# CITY OF ALBUQUERQUE

July 5, 2016

**Re: ABQ School of Excellence Charter School**  
**13201 Lomas Blvd., NE**  
**Traffic Circulation Layout**  
Engineer's/Architect's Stamp 6-28-16 (J22-D050)

B1 TRAFFIC CIRCULATION LAYOUT PLAN
1" = 40'-0"

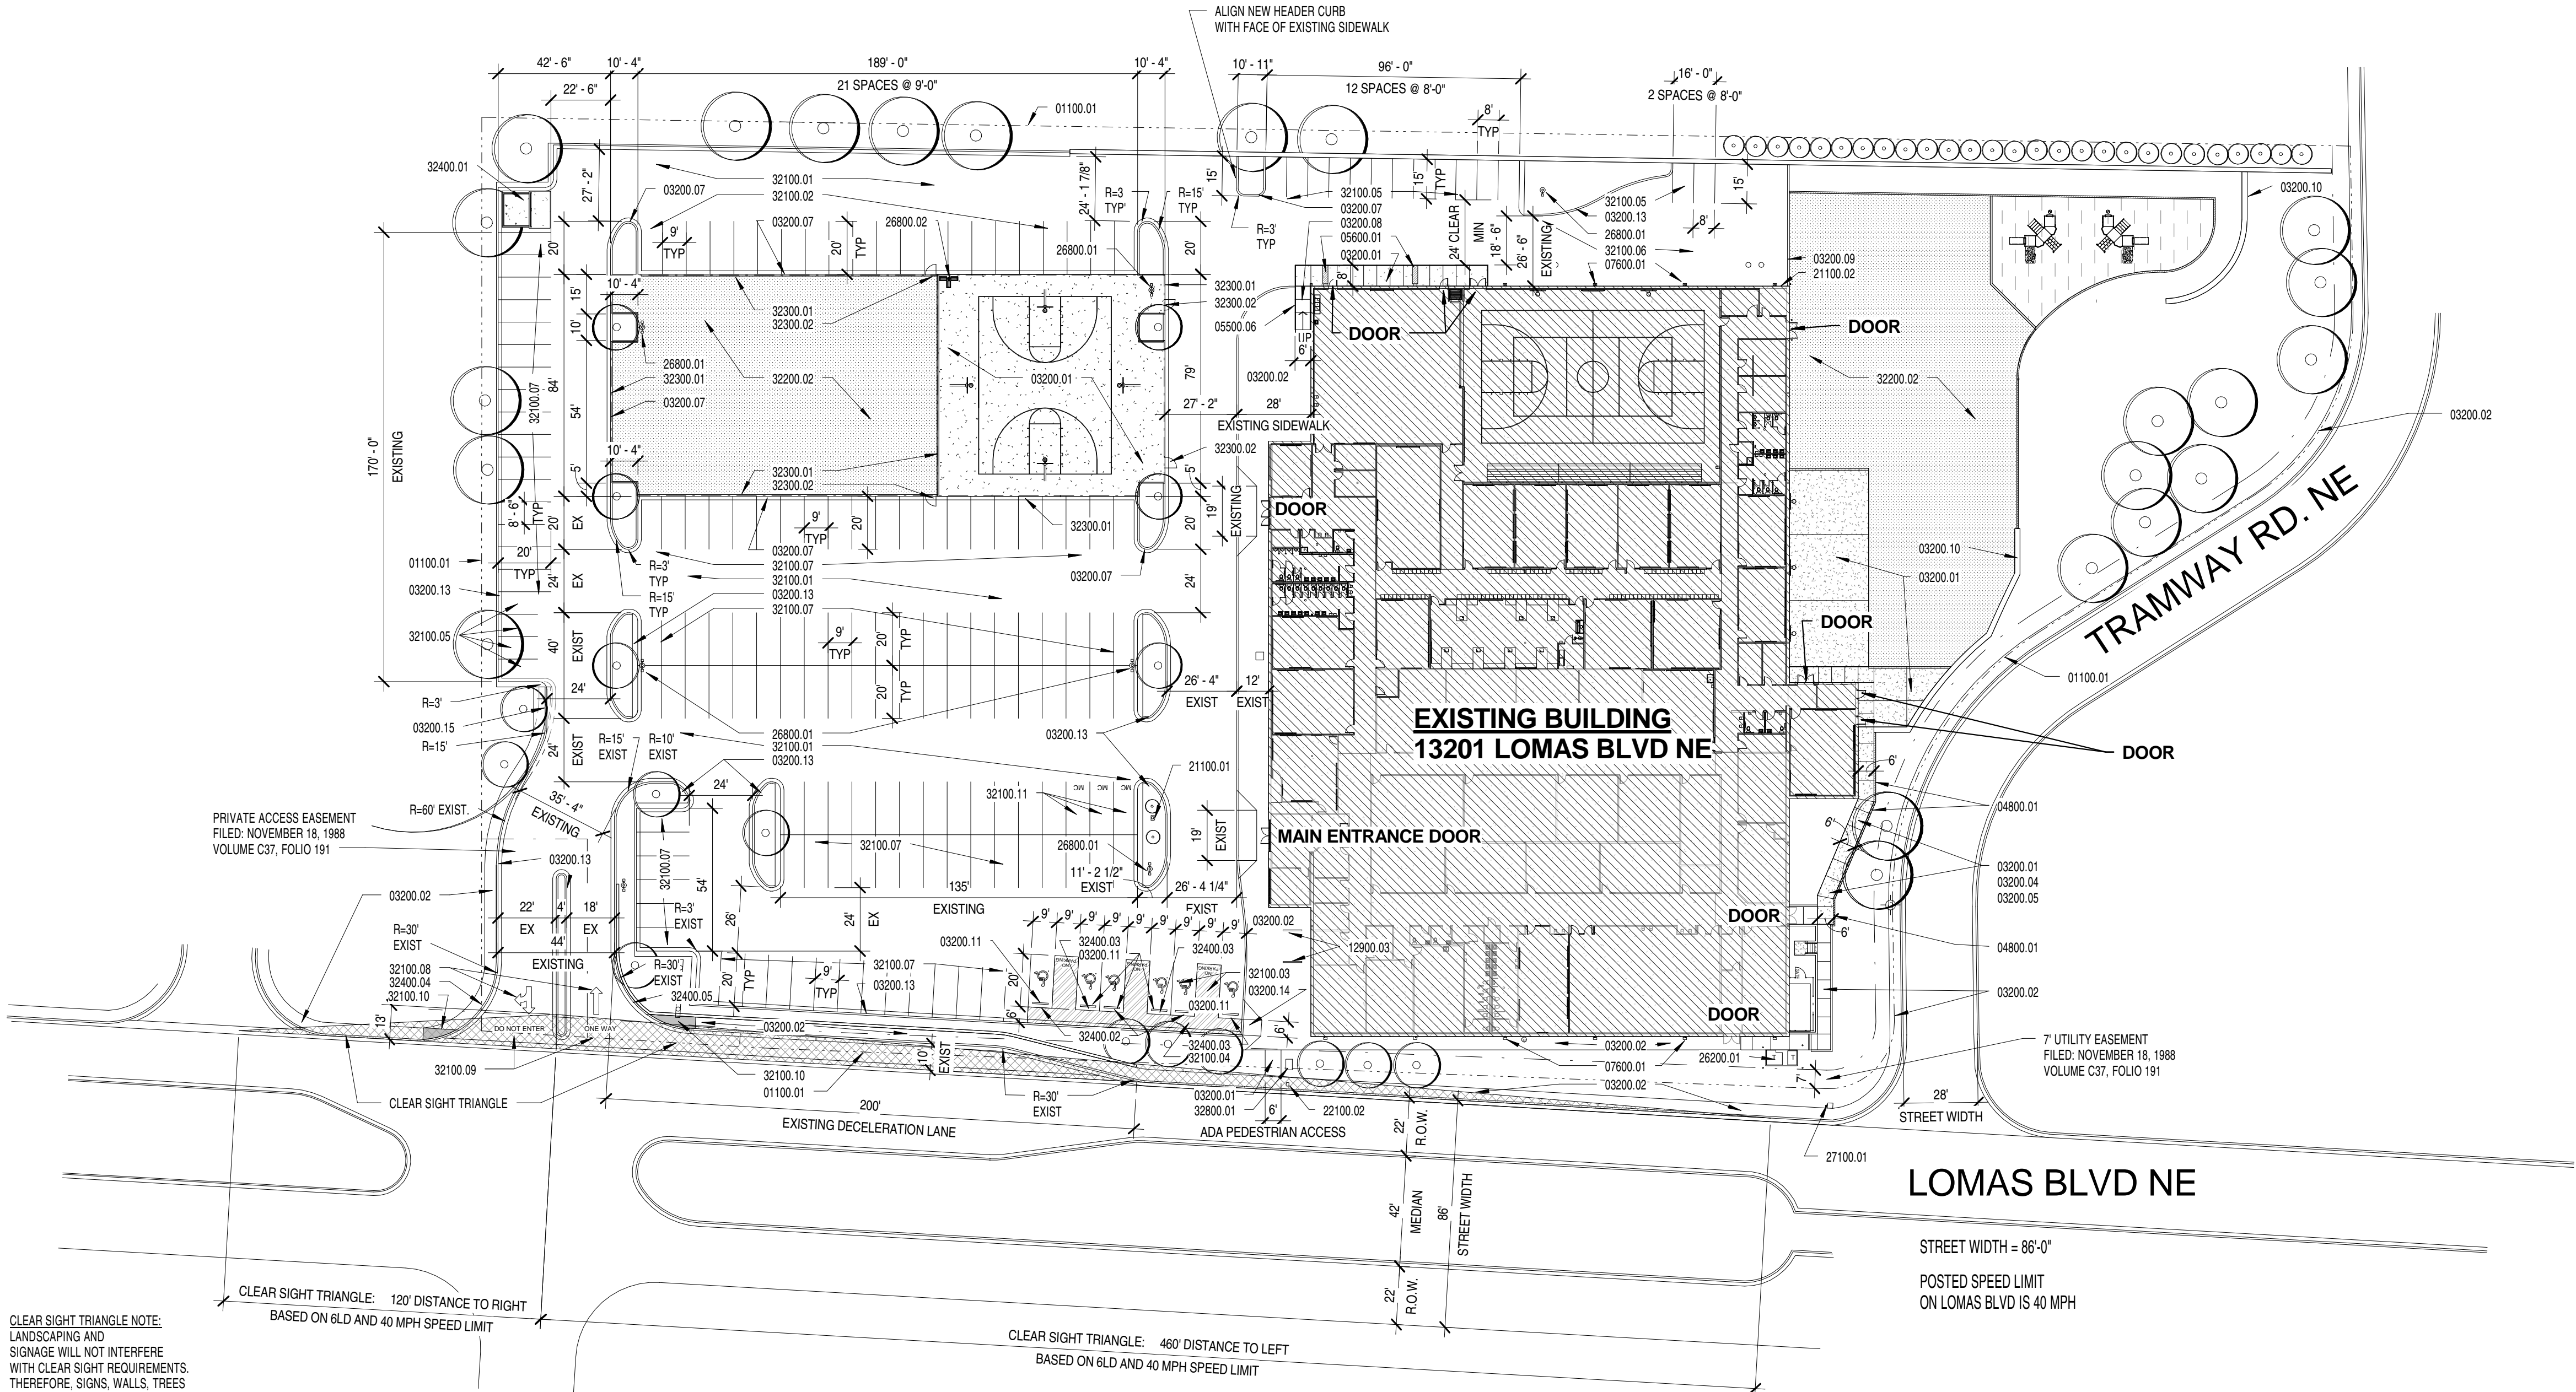
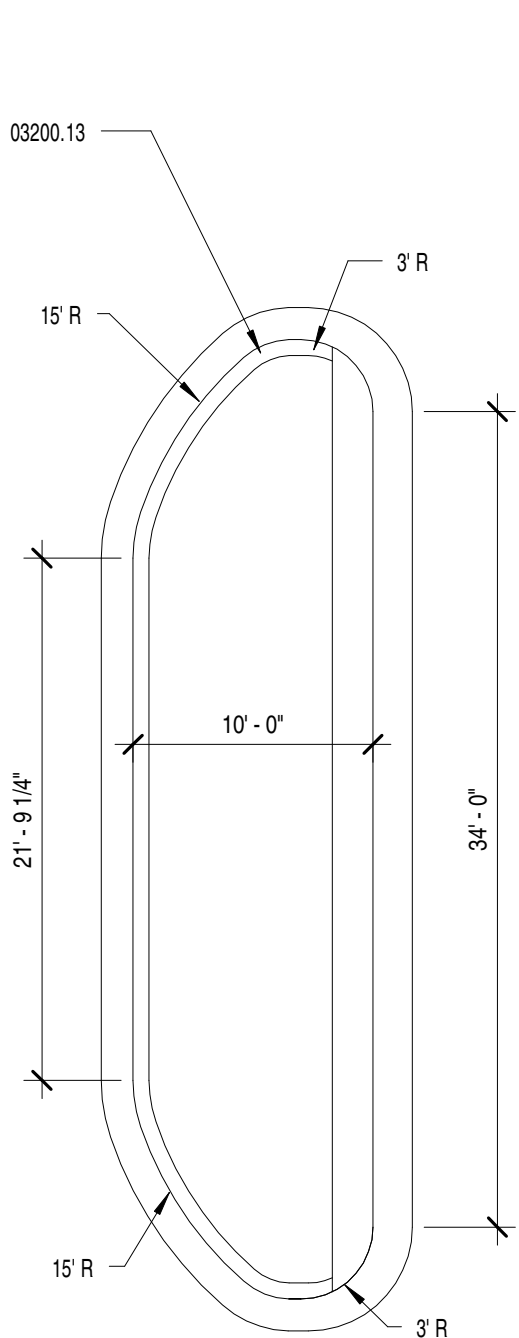
1. Please identify all existing buildings, doors, sidewalks, ADA ramps, curbs, drive pads, wall and anything that influences the parking and circulation on the site.

2. Please call out ADA ramps and truncated domes on drive pad crossings, which are required at all public ROW crossings.
3. Identify all existing access easements and rights of way width dimensions.

4. Identify the right of way width, medians, curb cuts, and street widths on Lomas Blvd. and Tramway Service Rd. Please detail the drive pad width north of the entrance off of Lomas Blvd.,

5. The handicap accessible spaces must be a minimum of 8.5 ft. in width.
6. The handicap accessible spaces must include an 8 ft. wide van access aisle; all other aisles should be 5 ft. in width.

7. The ADA accessible parking sign must have the required language per 66-7-352.4C NMSA 1978 **"Violators Are Subject to a Fine and/or Towing."** Please call out detail and location of HC signs.

8. The ADA access aisles shall have the words **"NO PARKING"** in capital letters, each of which shall be at least one foot high and at least two inches wide, placed at the rear of the parking space so as to be close to where an adjacent vehicle's rear tire would be placed. (66-1-4.1.B NMSA 1978)

9. Per DPM, a 6 ft. wide ADA accessible pedestrian pathway is required from the public sidewalk to the building entrances. Please clearly show this pathway and provide details. In review of the submitted drawing, the proposed ADA access from the ROW is 5 ft. in width.

10. Per DPM, a 6 ft. wide ADA accessible pedestrian pathway is required from the HC parking stall access aisles to the building entrances. Please clearly show this pathway and provide details. It not permissible to have the ADA access isle from the HC parking guide pedestrians behind parking spaces in order to enter building.

11. Provide a min 6" or max 8" high concrete barrier curb or other acceptable barrier between landscaping and parking areas and/or drive aisles. Please call out detail and location of barrier curb.

12. Service vehicle and/or refuse vehicle maneuvering must be contained on-site; provide a copy of refuse approval.
13. One-way vehicular paths require pavement directional signage and a posted "Do Not Enter" sign at the point of egress. Please show detail and location of

14. Please provide a sight distance exhibit (see the *Development Process Manual, Chapter 23, Section 3*). Please show this detail for the entrance/exit on Lomas Blvd.

15. Please add the following note to the clear sight triangle: "Landscaping and signage will not interfere with clear sight requirements. Therefore, signs, walls, trees, and shrubbery between 3 and 8 feet tall (as measured from the gutter pan) will not be acceptable in this area."

16. Please add a note on the plan stating "All improvements located in the Right of Way must be included on the work order."
17. All broken or cracked sidewalk must be replaced with sidewalk and curb & gutter. A build note must be provided referring to the appropriate City Standard drawing.
